158 Fore Street - Final Traffic Comments

Hi Nell – The following is a status update of April 8, 2016 preliminary traffic comments and represent my final comments.

SITE PLAN

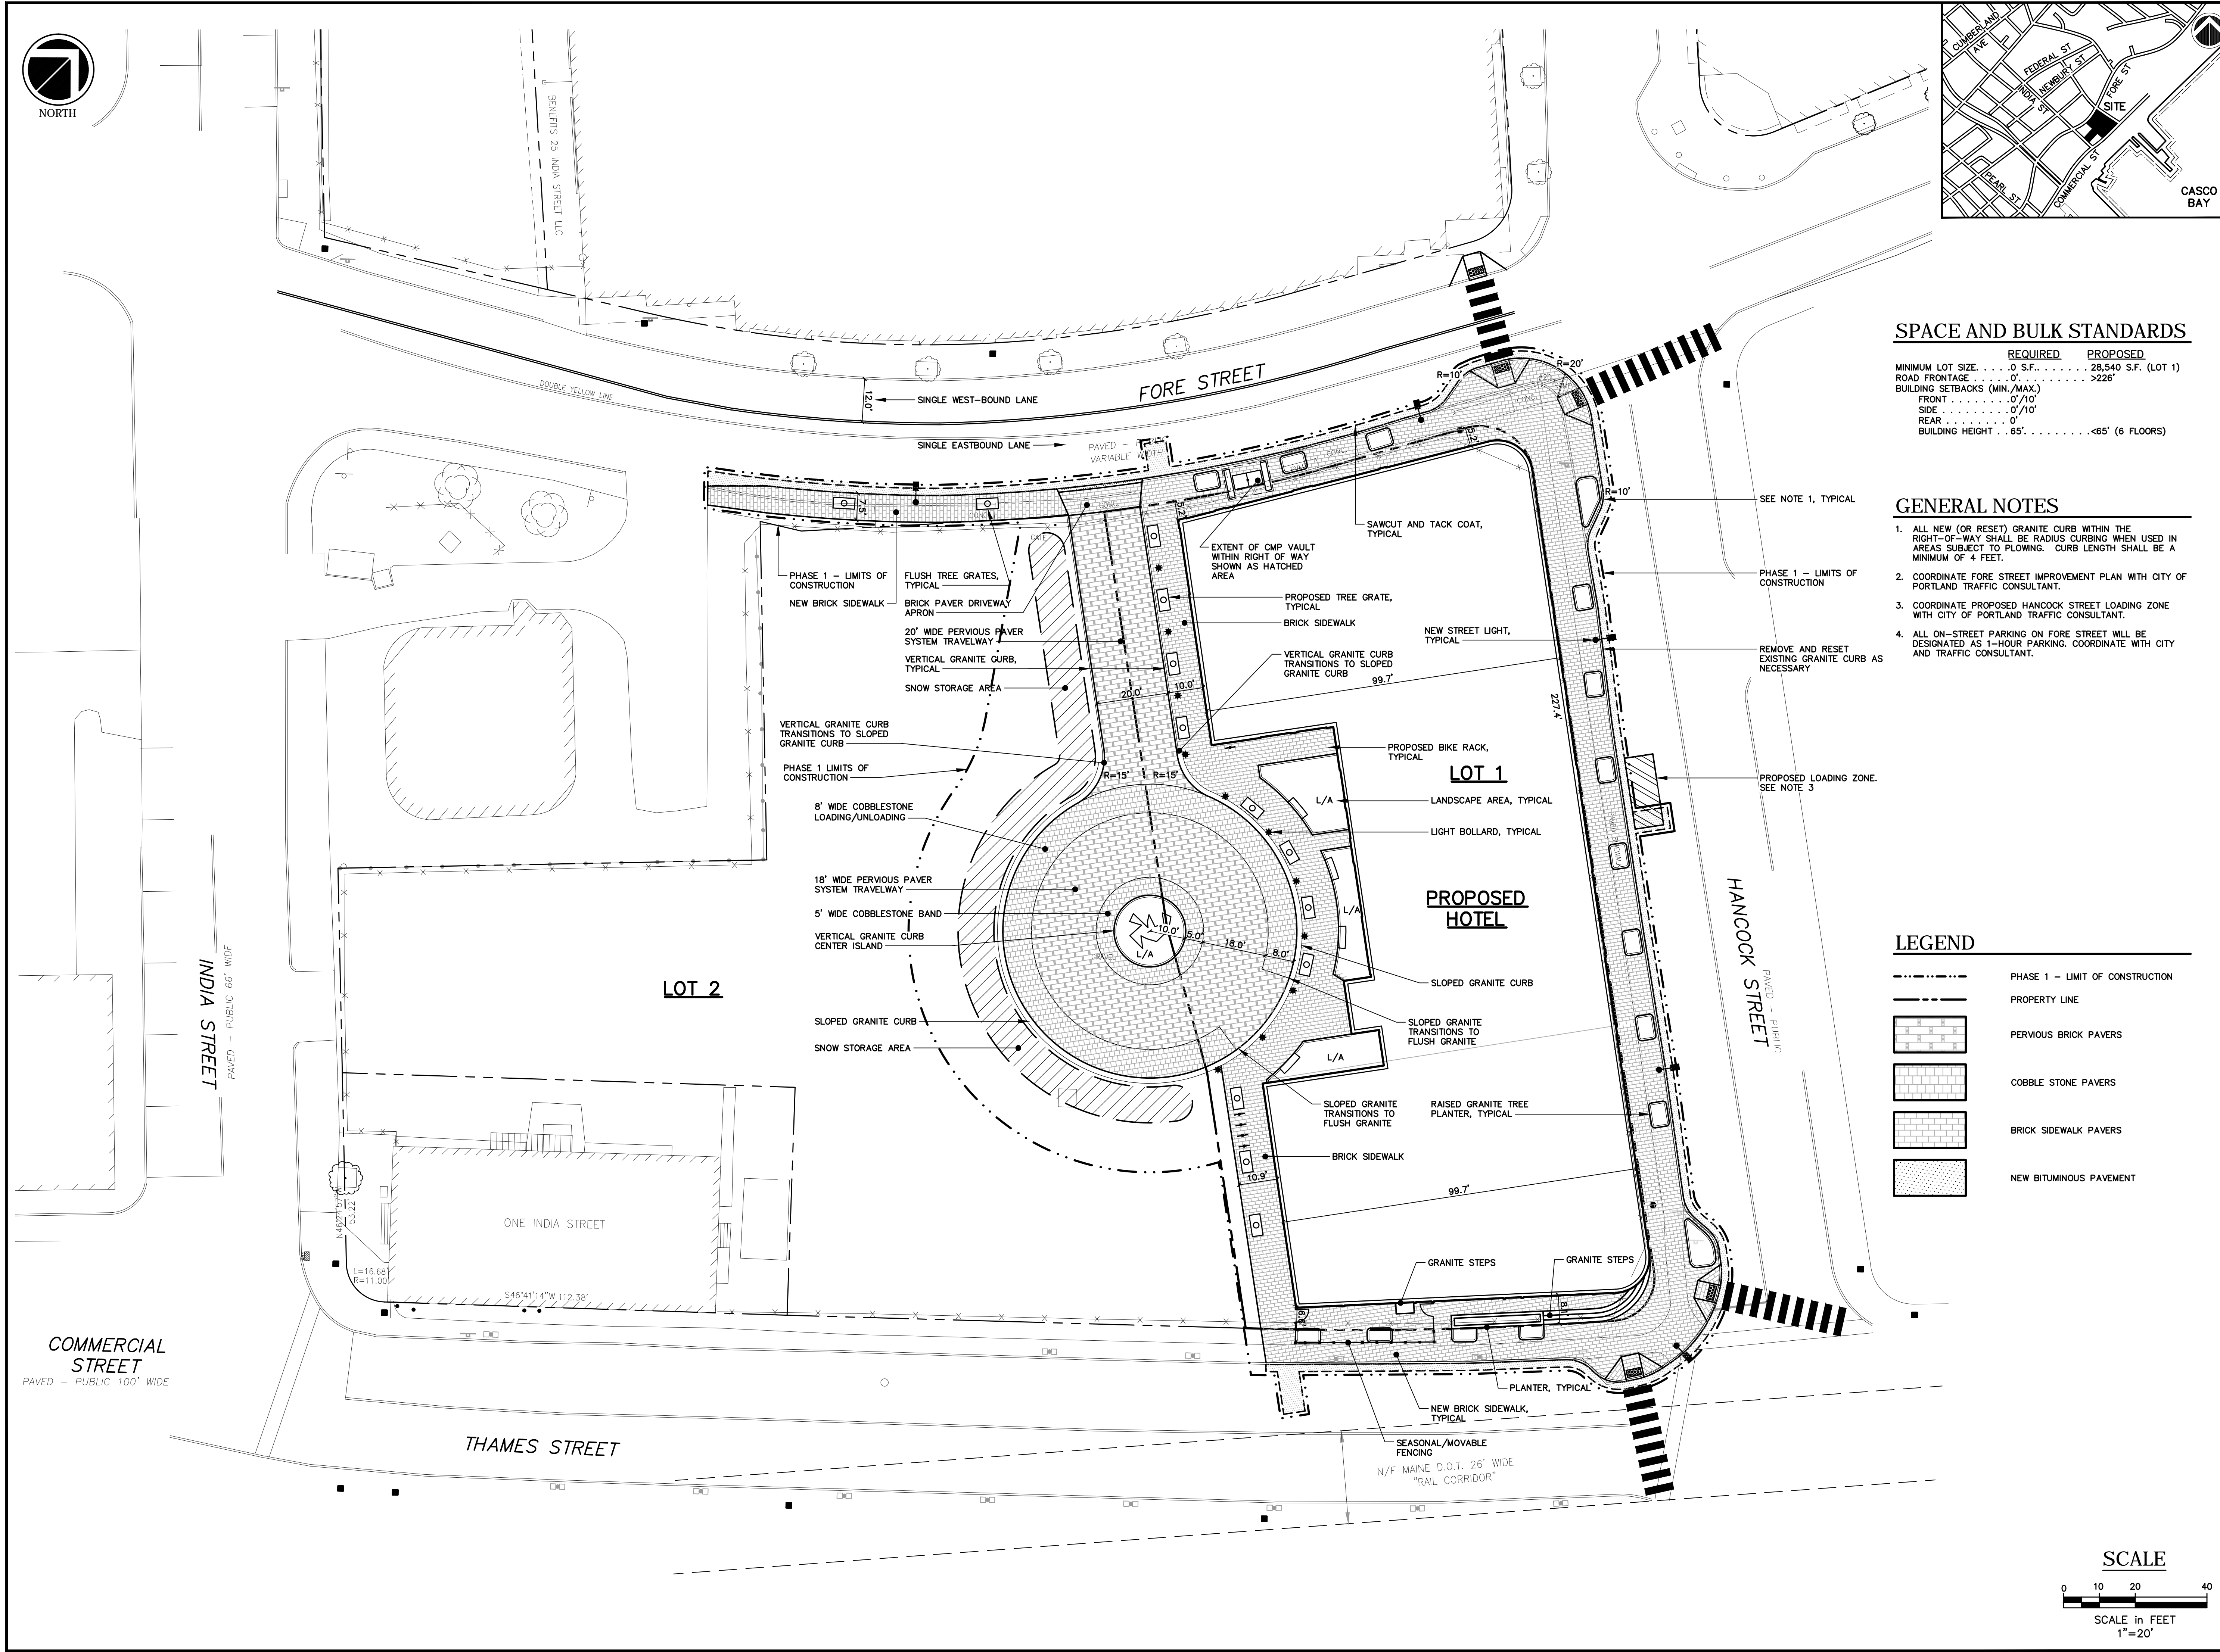
- It is my recommendation that a crosswalk be implemented on the west side of Fore Street at Hancock Street (particularly given use of the Gateway Parking Garage by the project). The crosswalk may include warning signs and shall be fully ADA compliant on both sides of Fore Street.

Status: The current plans do not address this comment. A condition of approval shall be included that requires the applicant to provide final ADA crosswalk, signage, and ramp details for review and approval. The applicant shall be responsible for implementation of the recommended design details. I would note the design shall be the preferred perpendicular crosswalk alignment and include ramps on both sides of

- City staff continues to review the curb extension at the southwest corner of the Fore Street/Hancock Street intersection. Alterations to the ramp configuration and depth of the extension will be required.

Status: Bruce Hyman is coordinating a final layout configuration for implementation by the applicant. I would also note that the applicant will be reconstructing the Hancock Street/Thames Street corner and the current curb extension as depicted on the site plan will need to be modified from geometric and ramp configuration perspectives. The City will provide direction on the configuration.

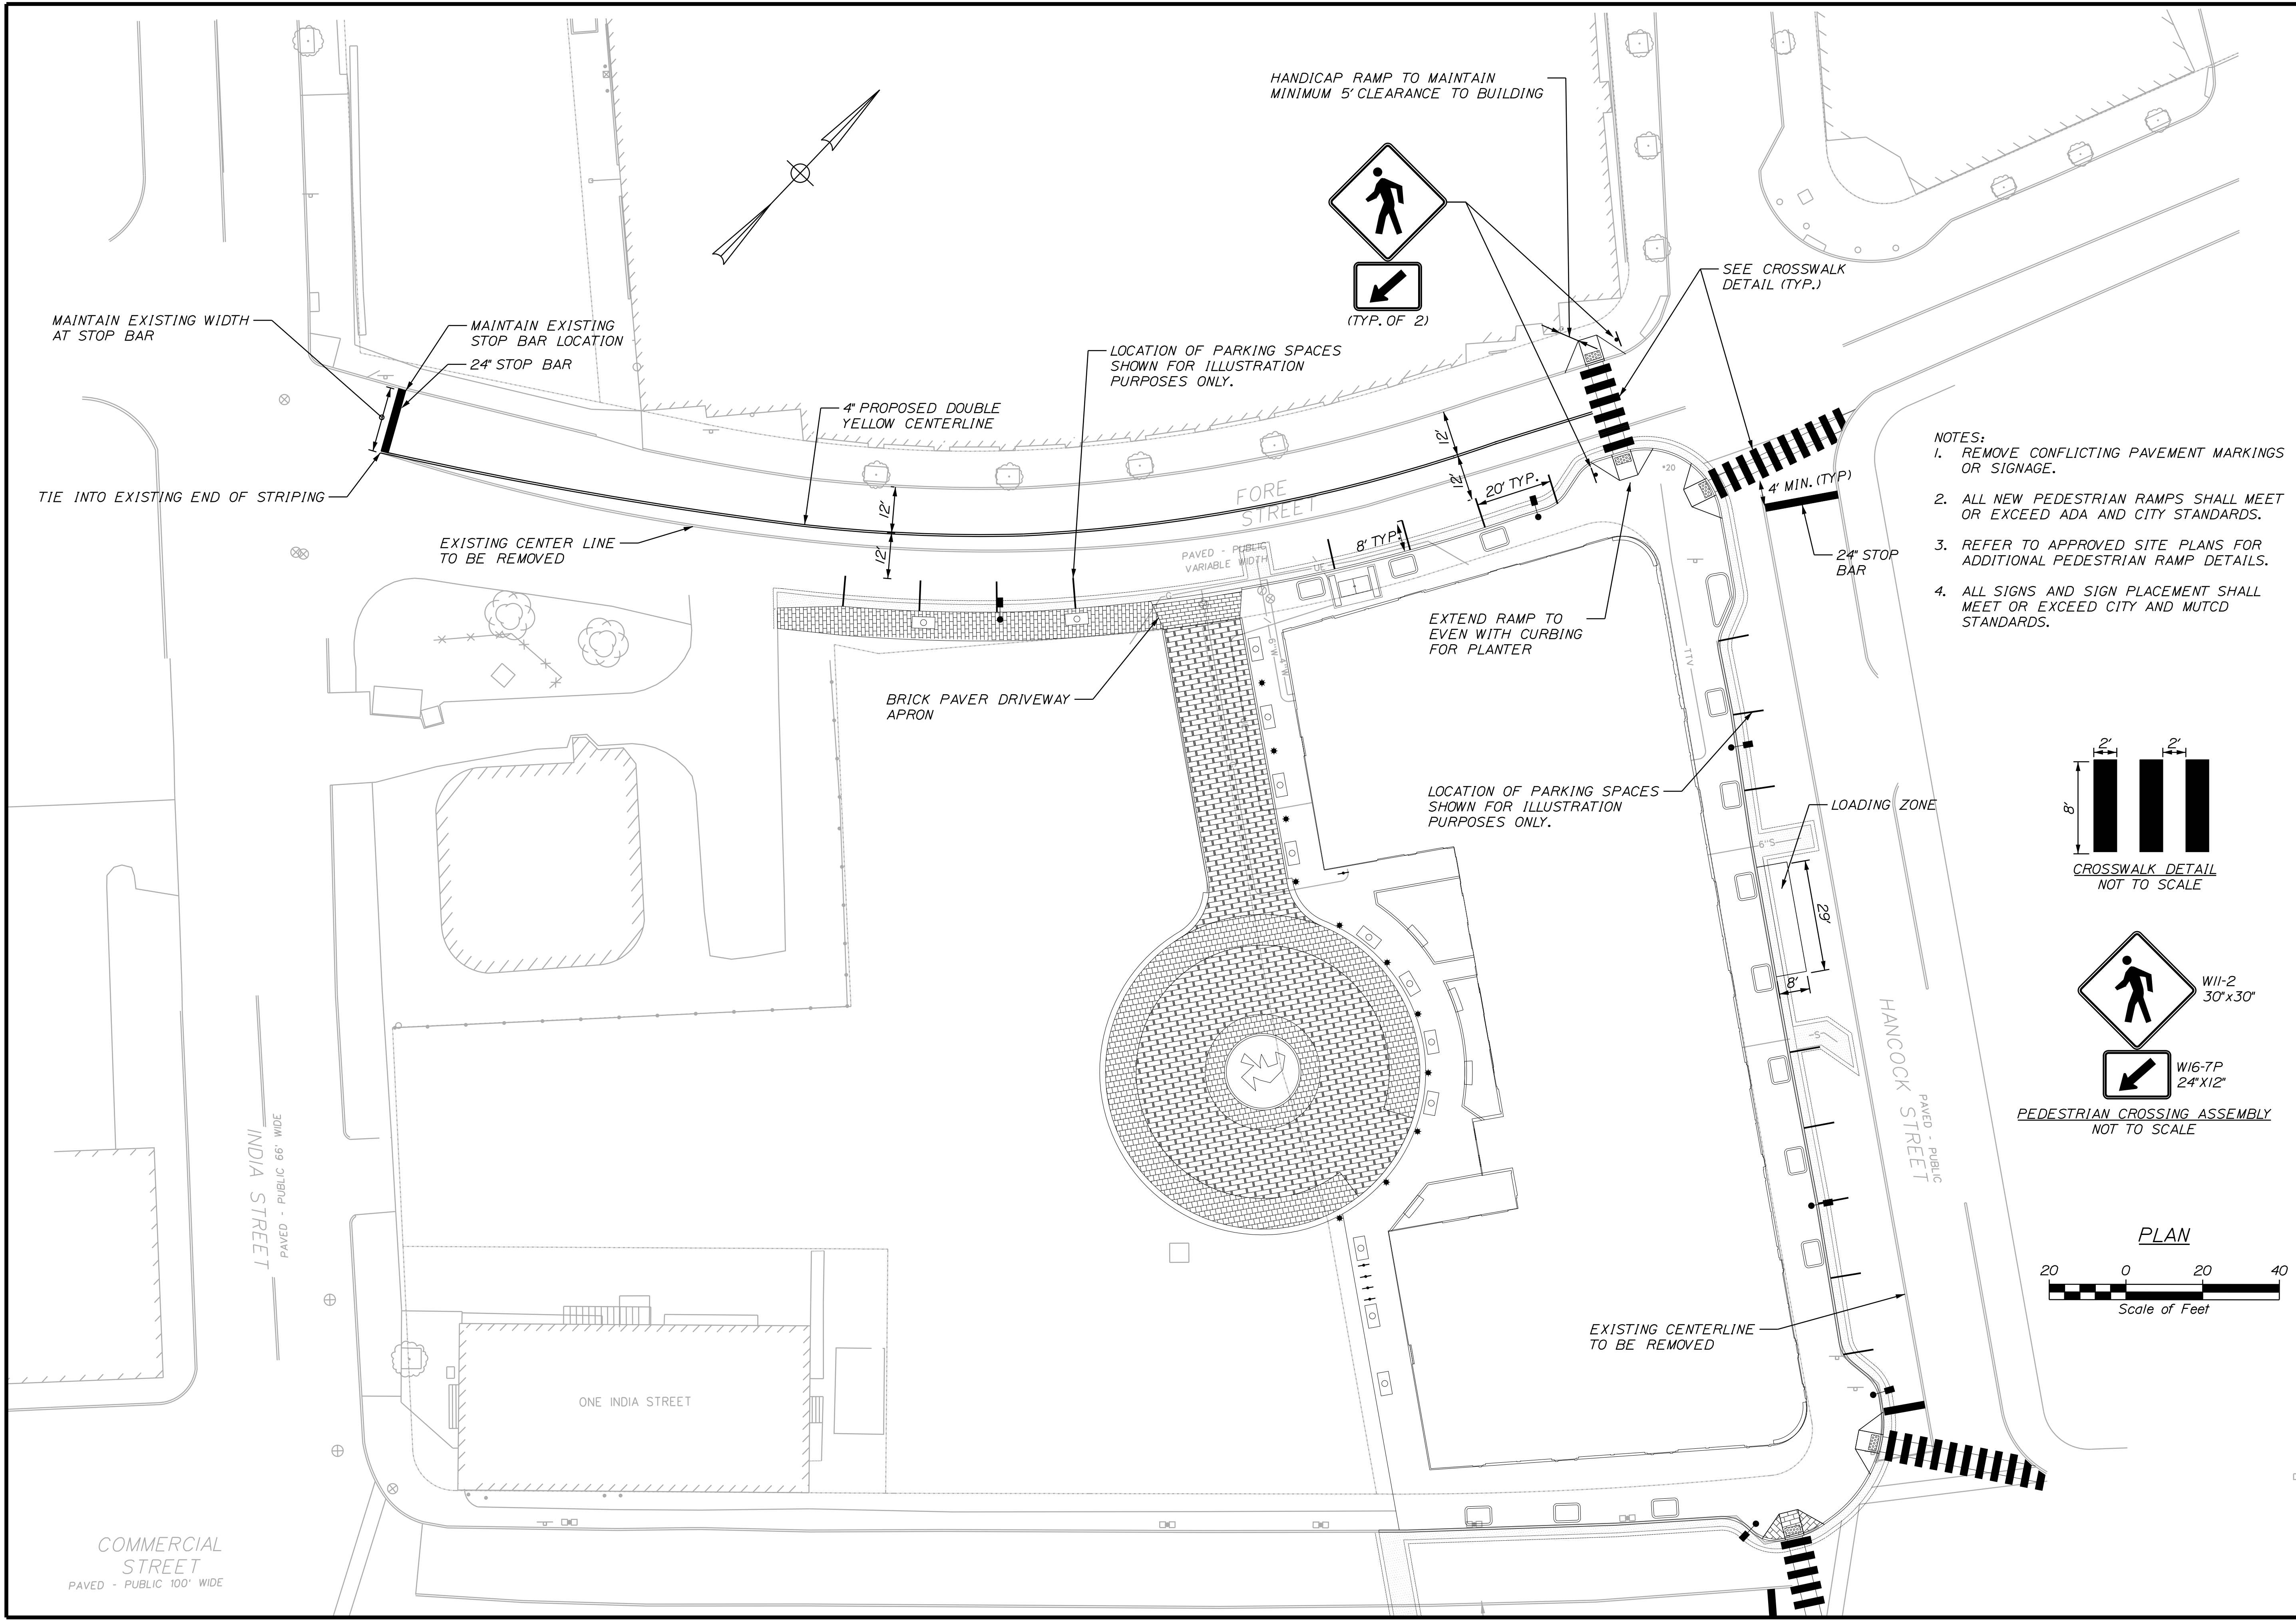
- The applicant will be developing a detailed pavement marking plan for Fore Street that depicts adjustment to the center line and implementation of on-street parking on the south side. I'll review the details upon receipt of the plan.

Status: A condition of approval shall be included that notes the applicant is required to prepare, for review and approval to the satisfaction of DPW, a pavement marking plan. The applicant shall be responsible for implementation of the plan. All details and specifications for implementation shall be approved by the City including but not limited to paint specifications and existing paint removal methods.
